SUBSURFACE WASTEWATER DISPOSAL SYSTEM APPLICATION

Subject: Approval, Replacement System Variance Request, Thompson Estate Property, Island Avenue, Cliff Island, Portland

We have completed our review of an HHE-200 Form dated 09/30/06 by John M. Toothaker, S.E. for your property at Cliff Island. You are proposing to replace an overboard discharge, with a 1,000 gallon septic tank, one OxyPro 1000 treatment unit, and three rows of four Eljen In-Drains. The disposal area has been reduced in size by 50 percent pursuant to Table 603.1 of the Subsurface Wastewater Disposal Rules, relating to treated wastewater. The test pit log on page 2 has no slope information in it. Notes #2 and #6 were not completed, on page 4 of the application. The following variances to the Rules, CMR 241 are requested:

Estate of Donald Thompson

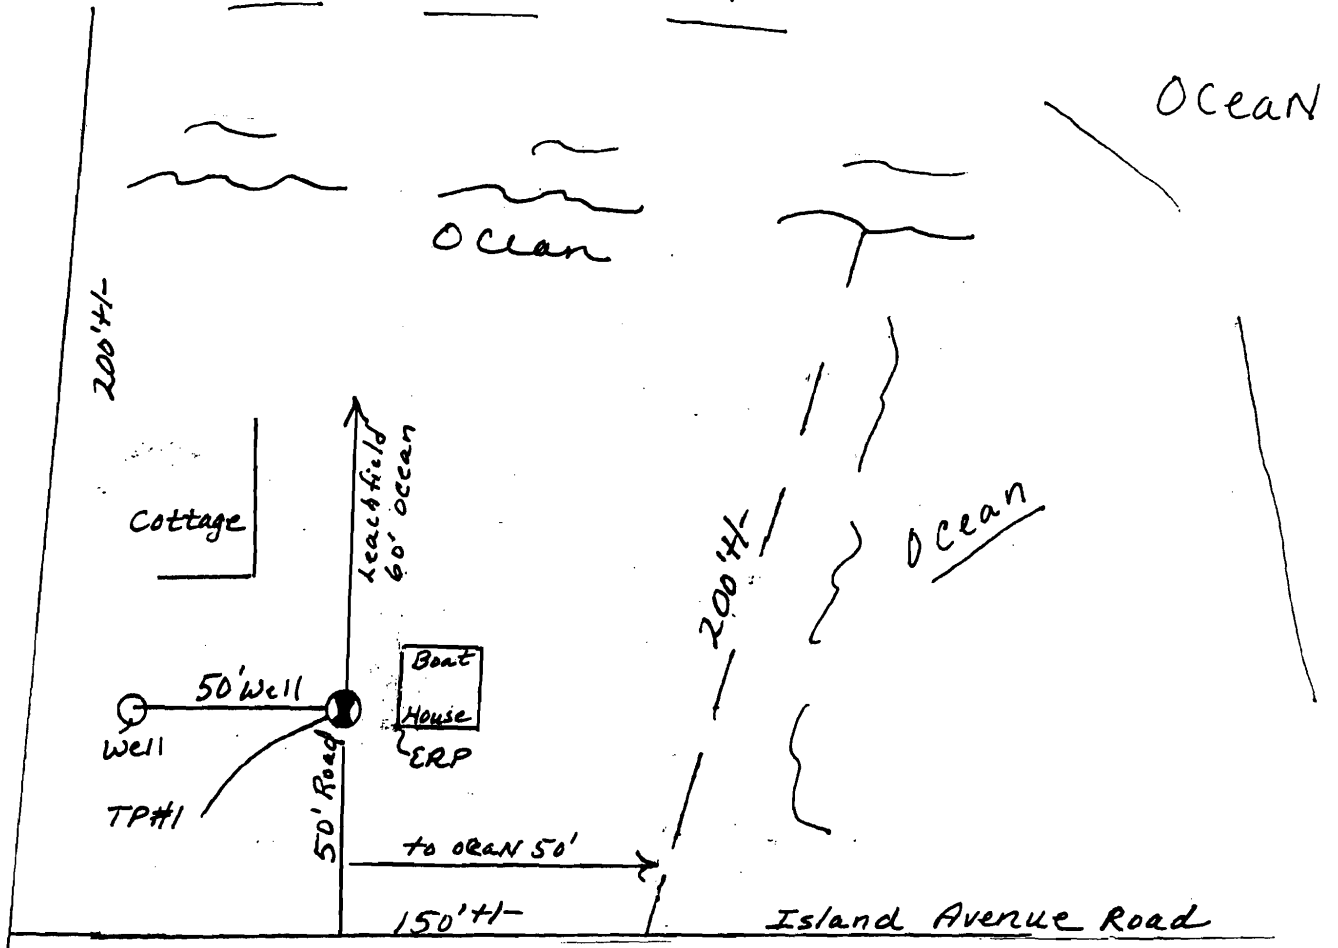
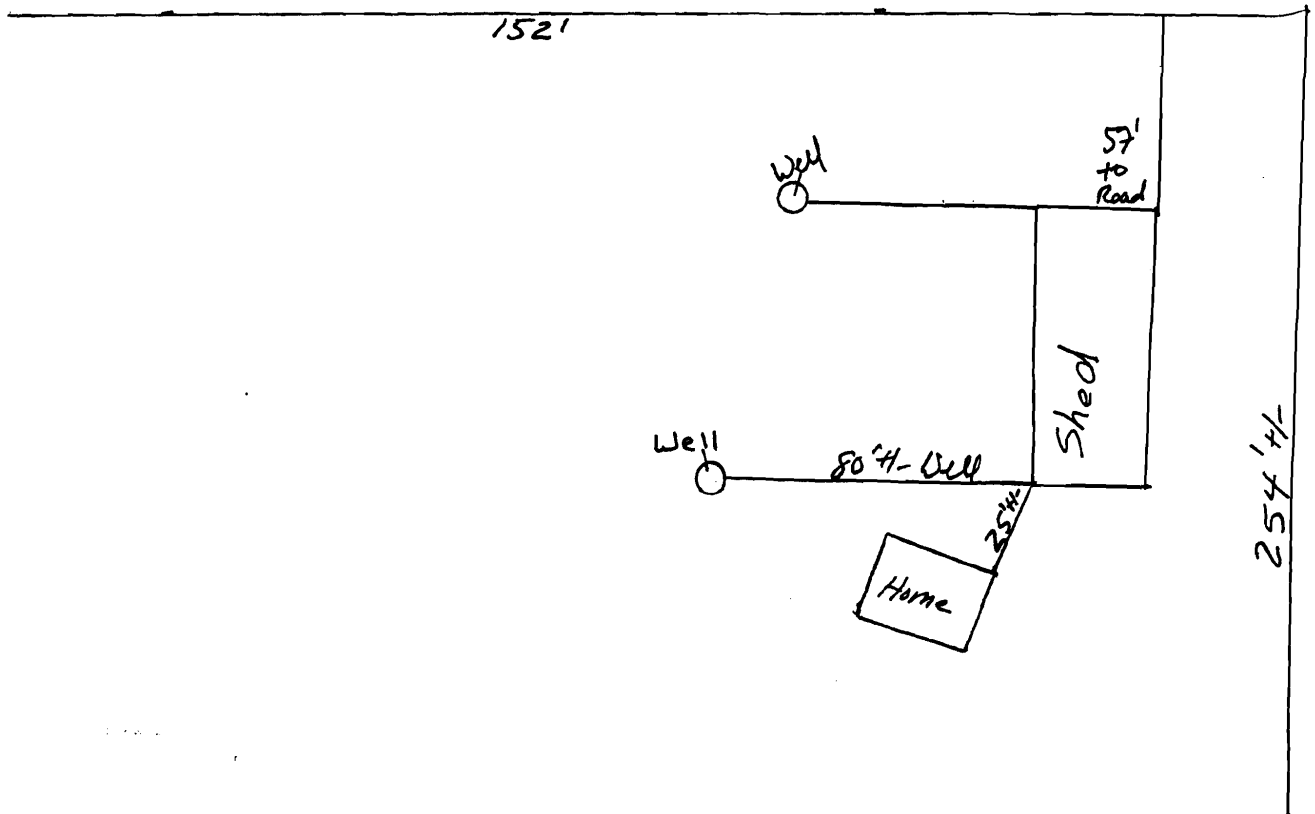
- 1. Prior to issuance of a permit to install the system, the Site Evaluator shall provide the owner and the Local Plumbing Inspector with a revised page 2 and page 4 of the HHE-200 Form, containing the data noted above.
